To	Justine Newby <newby.j@rootpartnerships.com.au>	Date 23 June 2020
Copies	Kate Tudehope <KTudehope@ethosurban.com>; Akshay Patel <patel.a@rootpartnerships.com>; Chris Crick <chris@rootpartnerships.com>	Reference number
From	Grant.Cuthbert@arup.com Camilo.Chalela@arup.com Glenn.Wheatley@arup.com	File reference 266969-AC05v2
Subject	Responses to DPIE SSDA acoustics comments

This memo provides responses to SSDA acoustics-related issues raised by NSW Department of Planning, Industry and Environment (DPIE) and NSW Environment Protection Authority (EPA) regarding submission related to the acoustic assessment for the Fort Street Public School SSDA (SSD 10340 Response To Submissions).

Figure 6: Acoustic screen around chillers

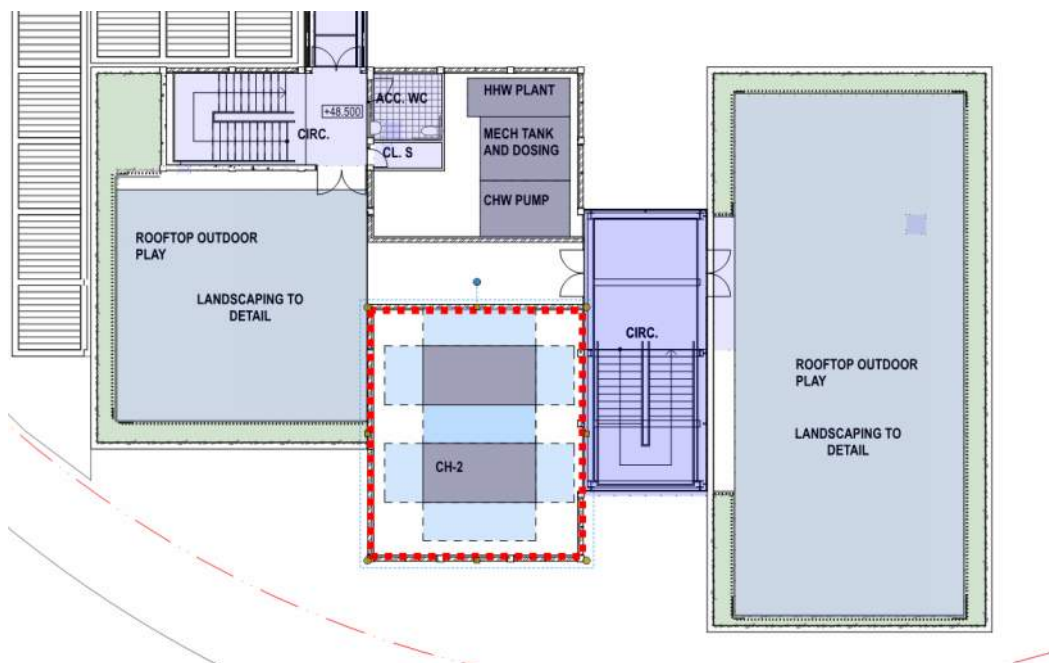
Acoustics—DPIE may wish to consider the implications of acoustic recommendation to install a 3m high acoustic barrier on the roof and have plant recessed into the roofscape.

The item raised does not direct a response from the proponent as it appears to be for consideration of DPIE. The recommendation for a noise barrier was based on preliminary design information for the mechanical design, noting that such a barrier would likely require approval given its impact on the built form. Depending on the final plant selection and mechanical design, the recommended noise barrier may not be required. However, prohibiting the installation of the barrier may limit opportunity to comply with the project noise targets. It is expected that resolution of the acoustic/mechanical design would be subject to further detailed design that could be deferred to prior to the issue of the construction certificate.
